Linda P. Tyler
52 Saint Lawrence Street
Portland, ME 04101

20 January 2014

Thank you for the attentive consideration you gave to the details of the 118 Congress project on 17 December. I spoke at that meeting and voiced my appreciation for the architectural design of the building. While I still appreciate the building's aesthetics, I ask for your further consideration for:

A2.01

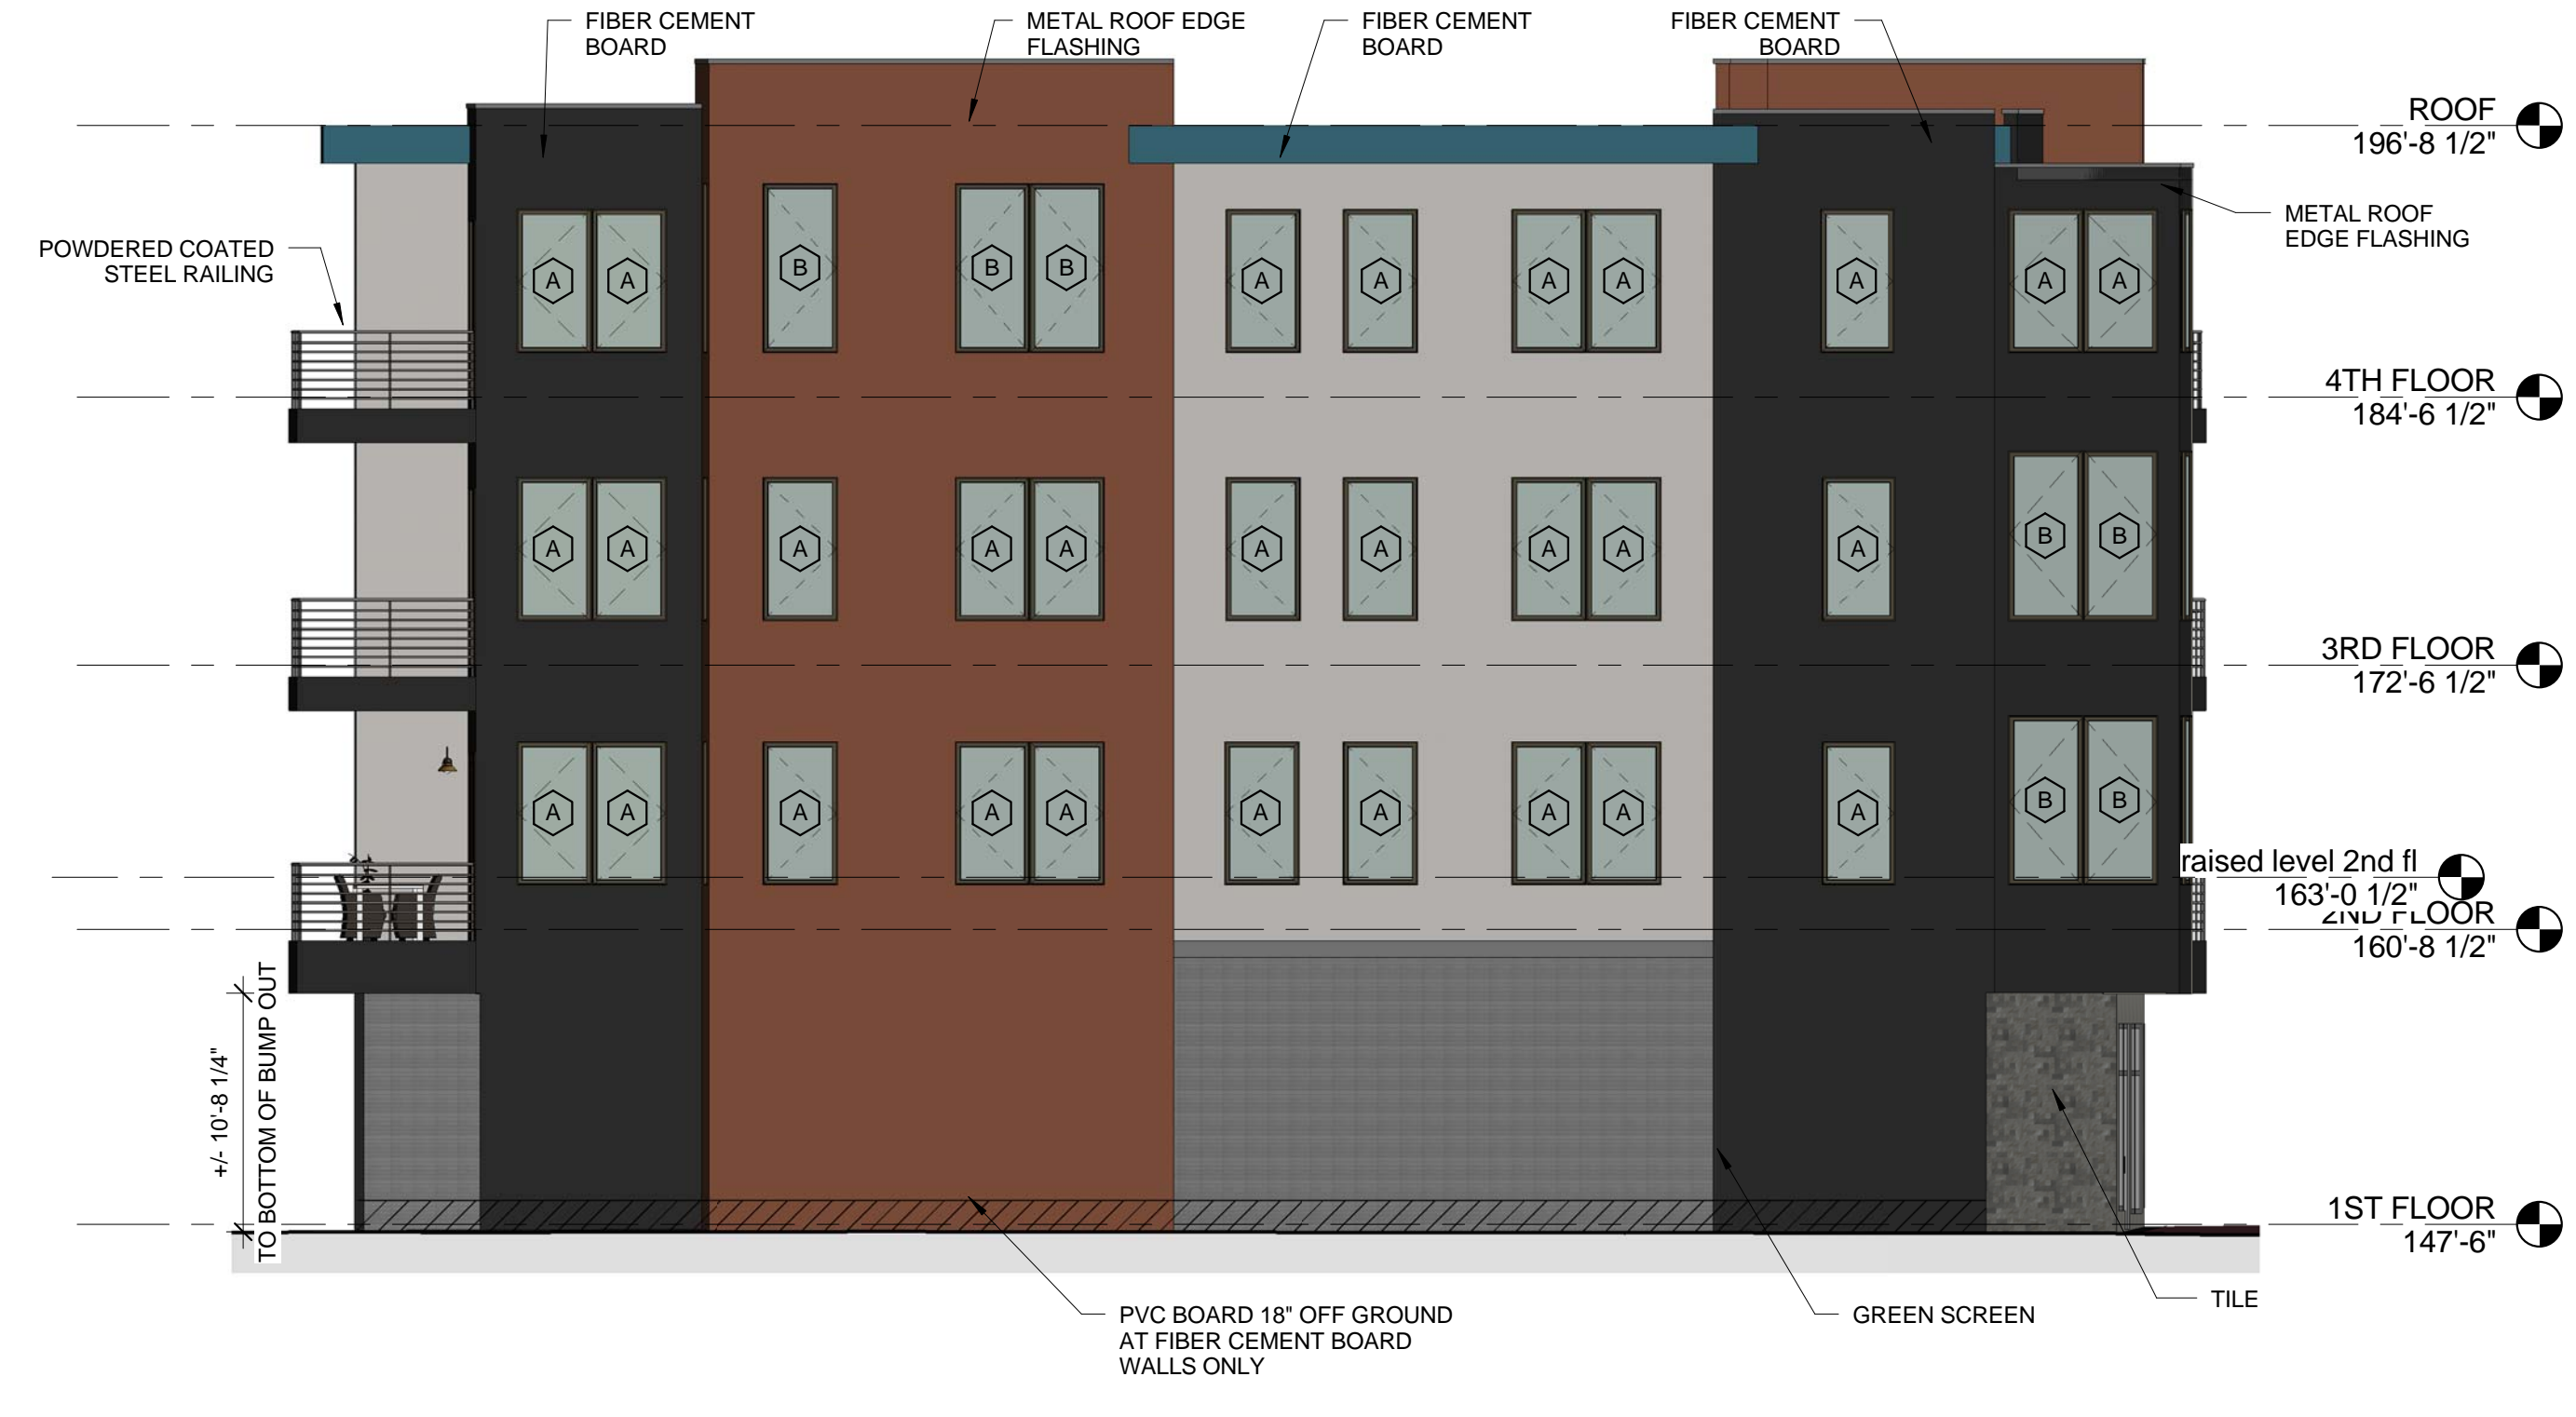
--easement: the overhangs over the sidewalk would present both visual and, more important, safety problems;

--set-back: the compromise proposed by the developers regarding the board's request for a set-back of two and half feet (if I remember correctly) to one foot is unacceptable; I cringe when I see the "Line Diagram Looking Westerly up Congress" and the "Line Diagram Looking West on Congress St. Sidewalk." I blacked in the space within the the diagram's outline and went from cringing to being horrified. I see, rather than visual interest from the vantage of human scale at pedestrian level, a severe disruption;
